1 August 2024

SSD 67175465
JD6 (P&E)

STATE SIGNIFICANT DEVELOPMENT APPLICATION 67175465
APPLICANTS: CBUS PROPERTY, GALILEO GROUP, PLATFORM PROPERTY SERVICES

### Building B1 shifted

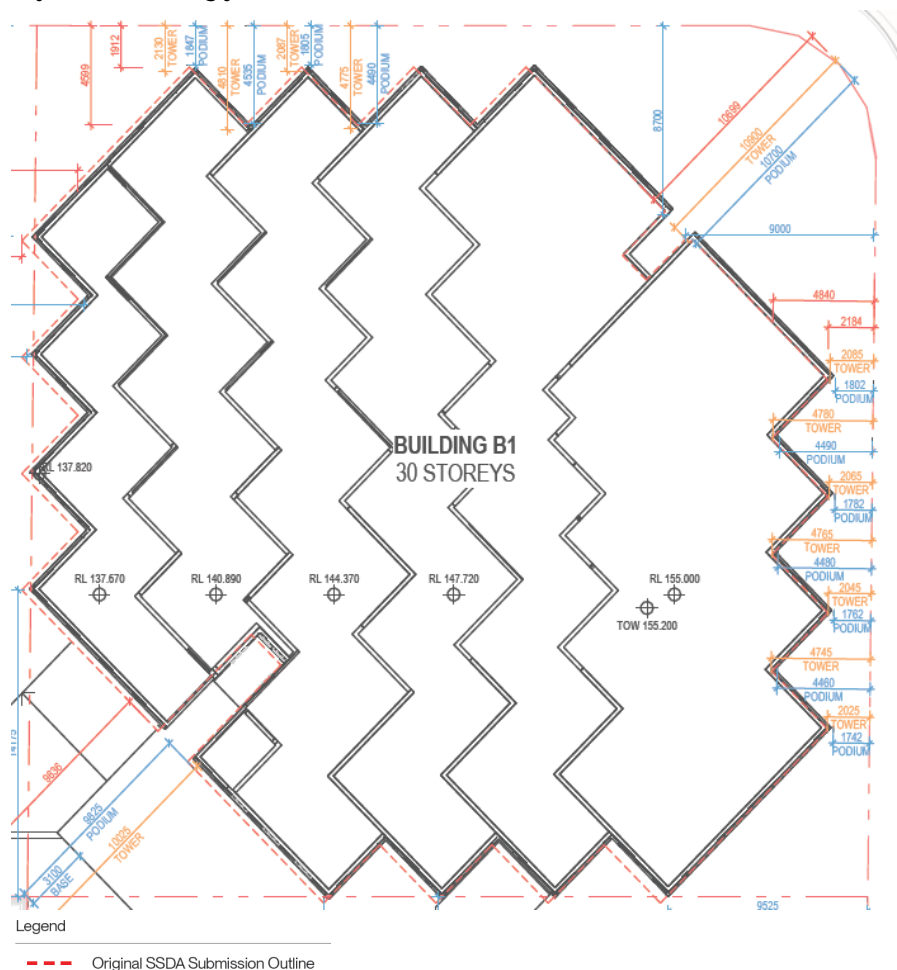
The proposal provides an above podium setback of 850mm to Building A and 270mm to Building B1. Despite non-compliance with the DCP, the serrated articulation to Building B1's tower and podium helps to visually mitigate the scale and bulk of its basic shape. Its corner location allows some flexibility in a reduced above podium setback to Building B1 and is therefore considered acceptable.

**Figure 2** Amended building footprints and Setbacks for the Amended Development

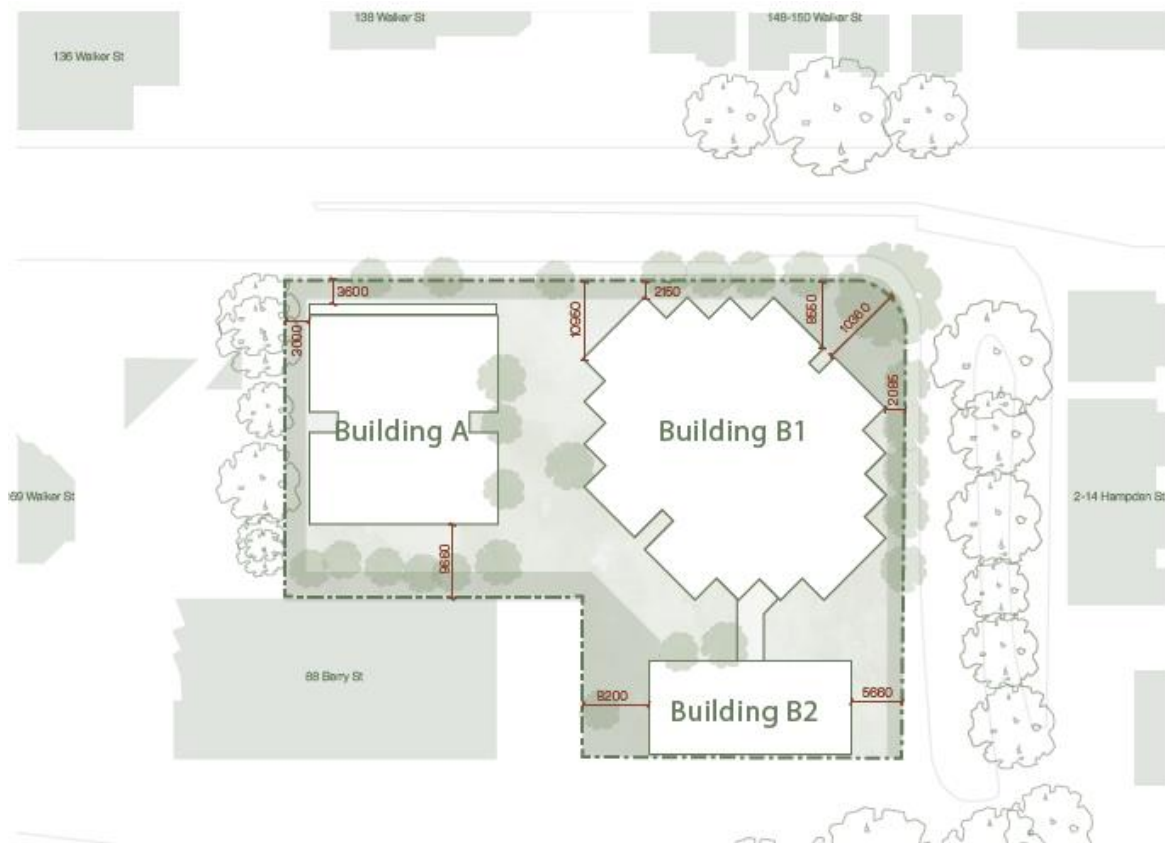
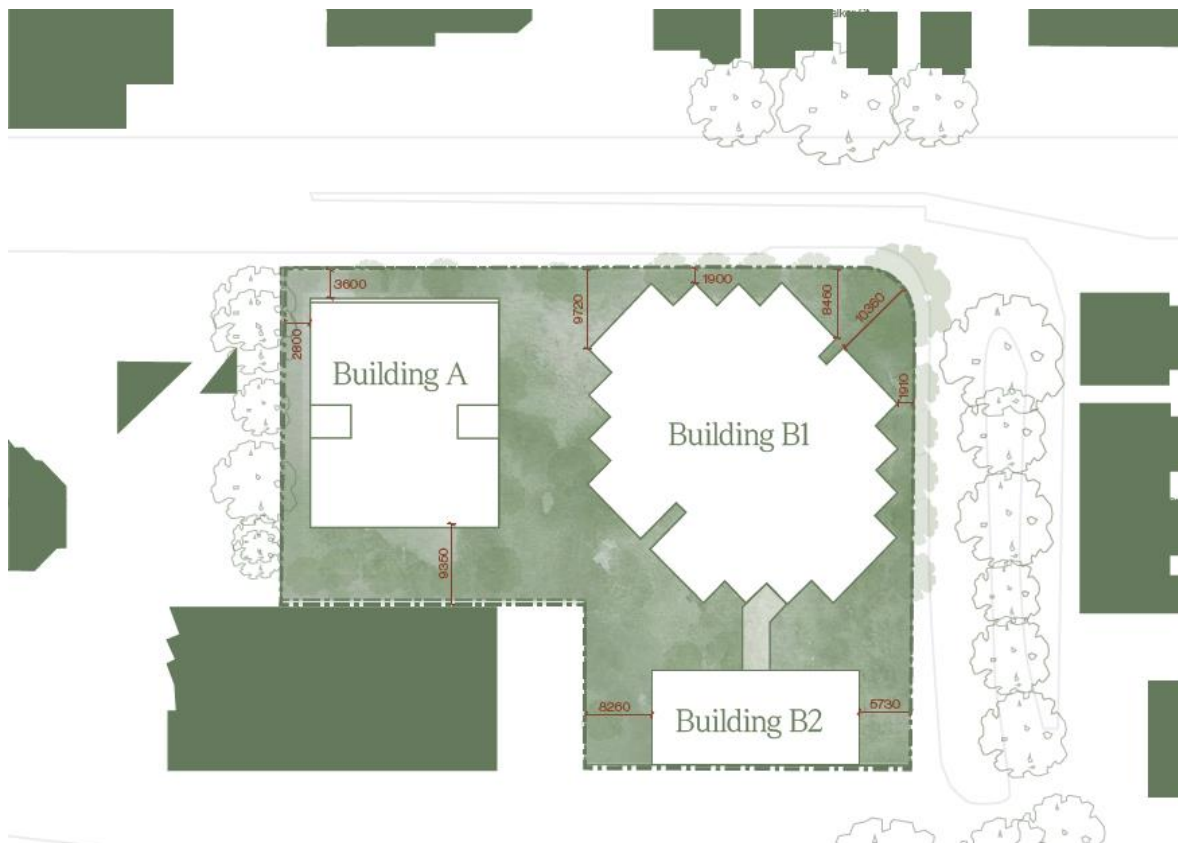
In contrast, Building A (the 12-storey affordable rental housing building) presents a continuous podium and tower form to Walker Street. The lack of above podium setback, particularly to the street, increases its perceived bulk and mass, which is not in keeping with the desired street character. Increasing the podium setback to 3.0 metres on the western façade of Building A along Walker Street is recommended to enhance the human-scale and quality of the streetscape.

1. Increase to 3 metres the above podium setback provided to Building A's western façade.
2. The design be reviewed to clarify and make more legible and useable, the main entrances to Buildings A and B1, and clearly delineate between public and private spaces.
3. For reasons outlined above and other reasons described elsewhere in this report, the porte cochere must be replaced with an on-street kerbside delivery and pick-up space and the vehicular entry and the loading bay on Hampden Street must be revised.
4. Consideration being given to enhancing the amenity provision for Building A, including equitable access to communal recreational spaces in Building B2, to ensure parity within the development, overall.
5. Increasing building separation distances to comply with the Apartment Design Guide.
